**BILLIARD Residence**  
 5980 Burgess Road  
 Colorado Springs, COLORADO  
 EL PASO COUNTY

**C1.1b**  
 SITE PLAN

SFD191035  
 ADU1949  
 ZONE: RR-5  
 AREA: 36.2 AC  
 DIST: 1

C1.1b
SITE PLAN

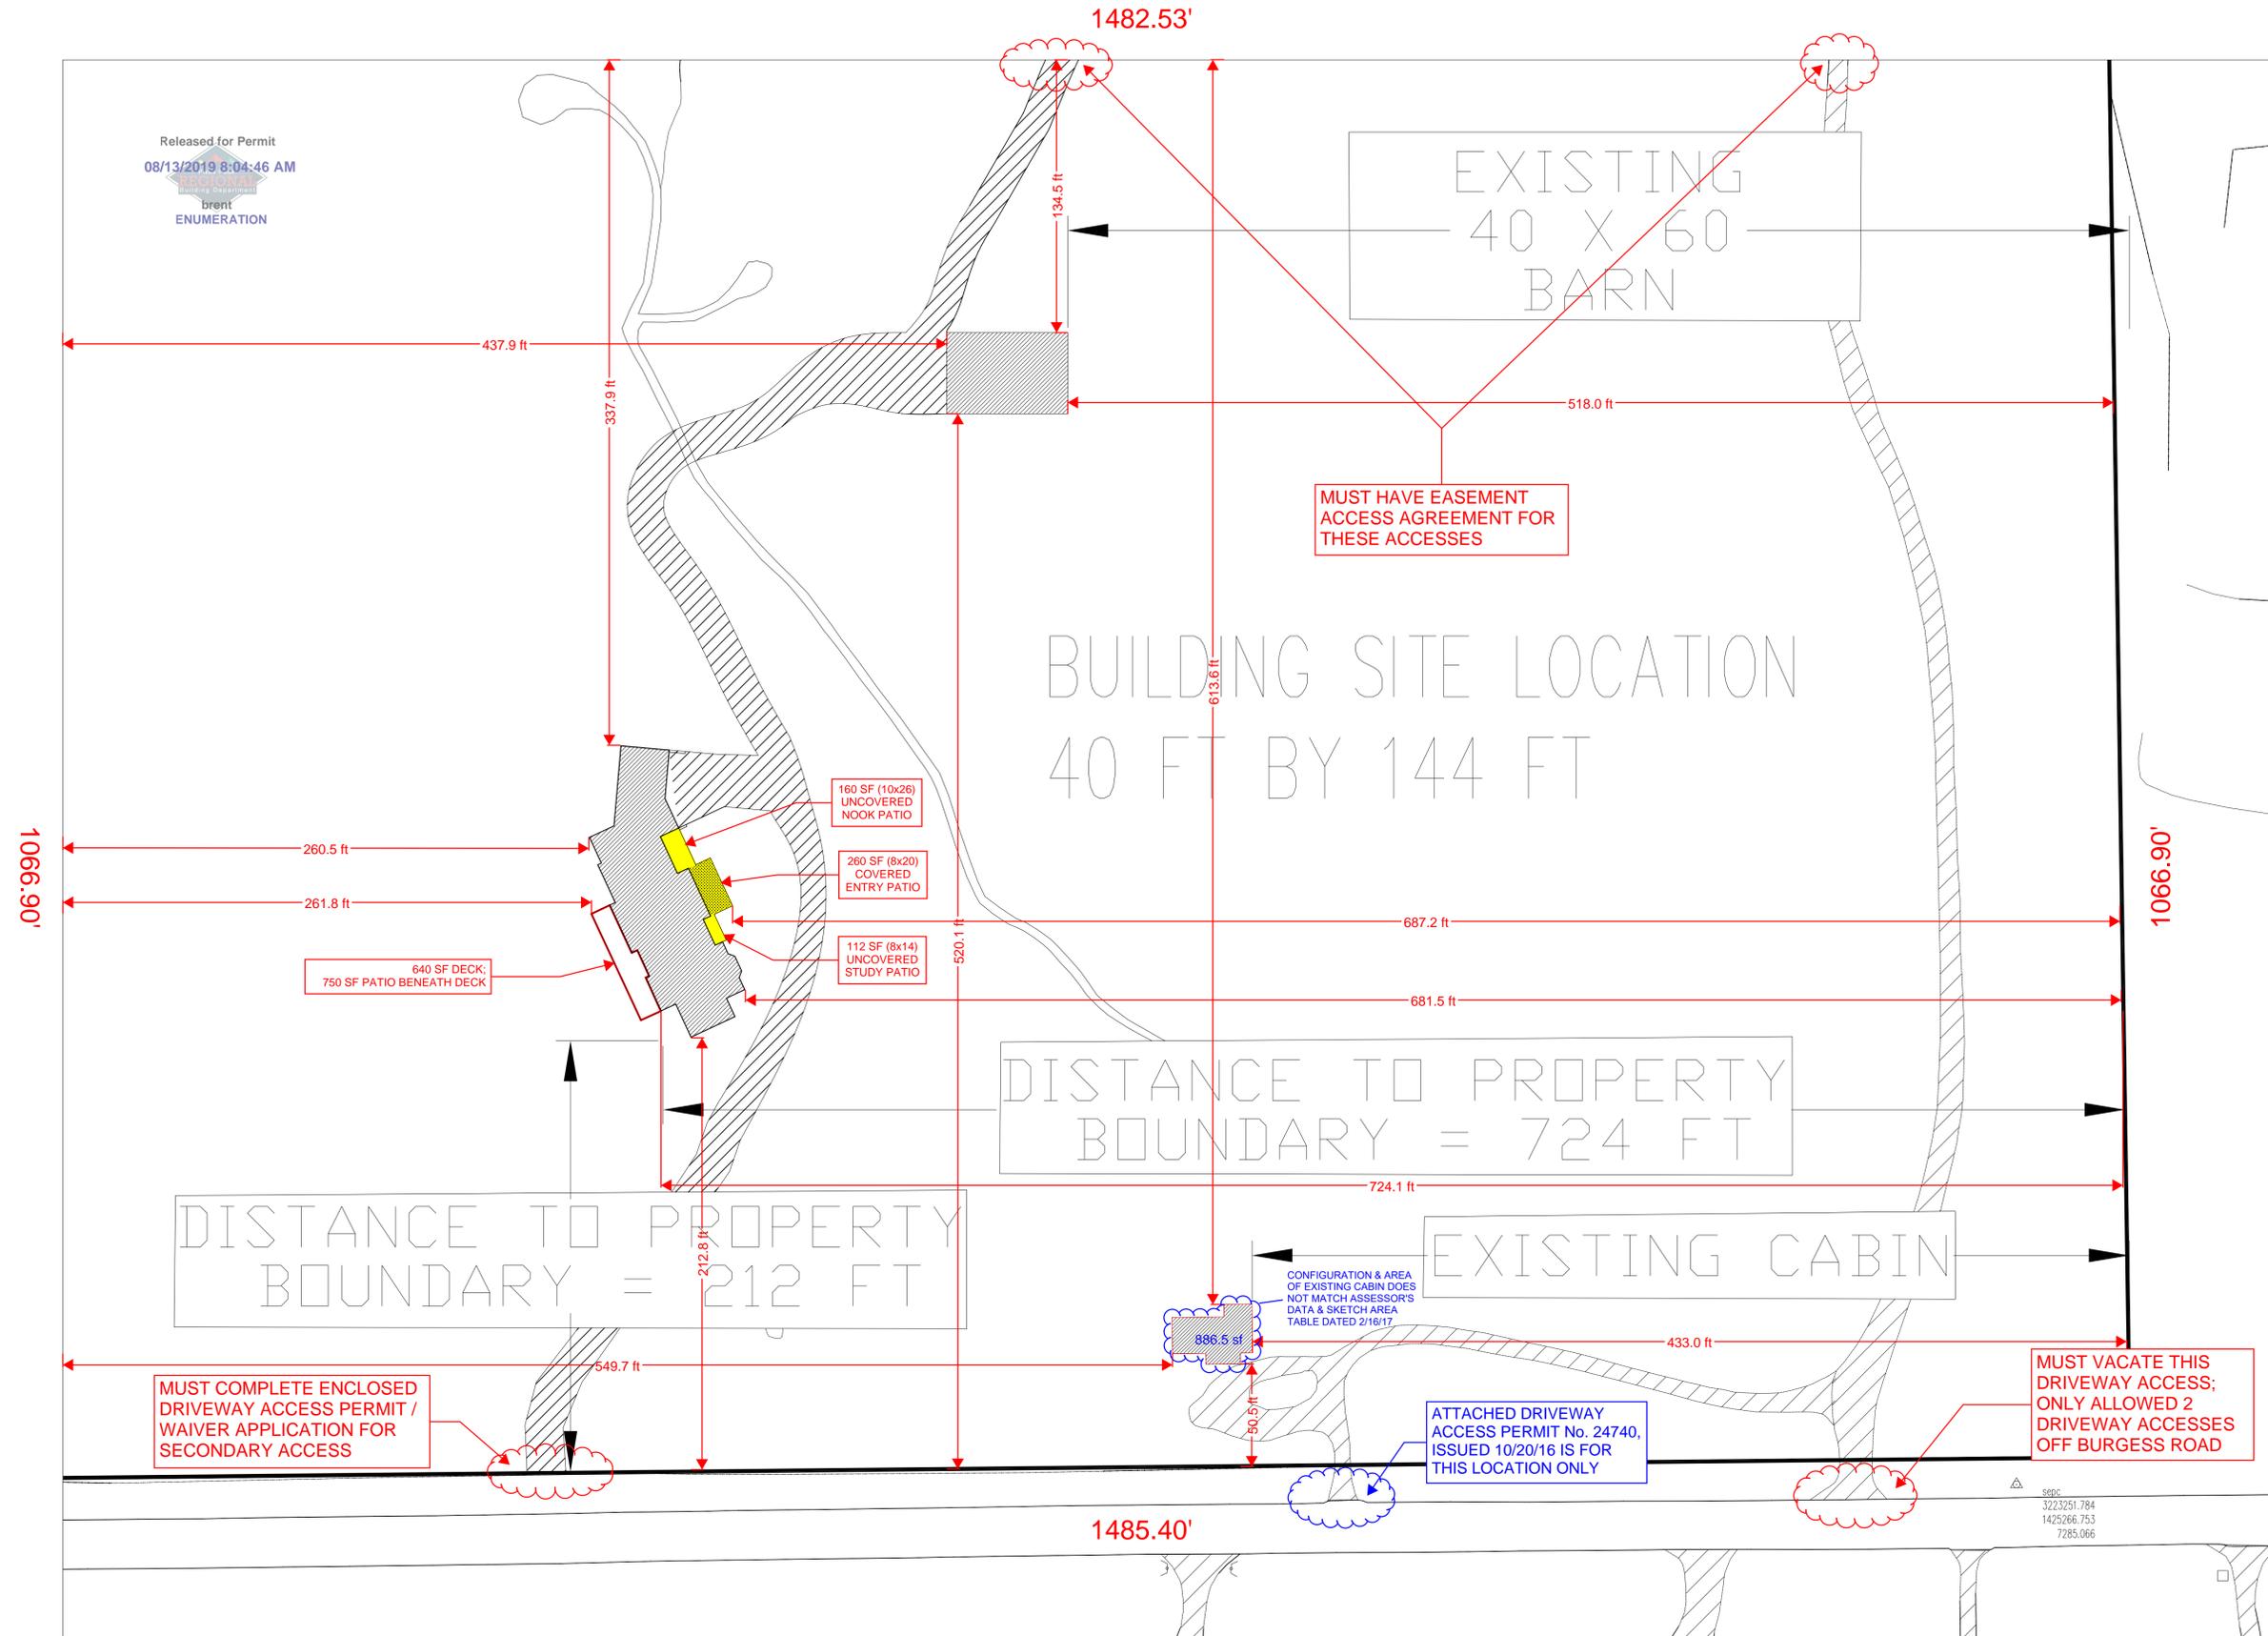
**CONFIGURATION & AREA OF EXISTING CABIN DEPICTED ON SITE PLAN DOES NOT MATCH CURRENT ASSESSOR'S DATA & SKETCH AREA TABLE DATED 2/16/17.**
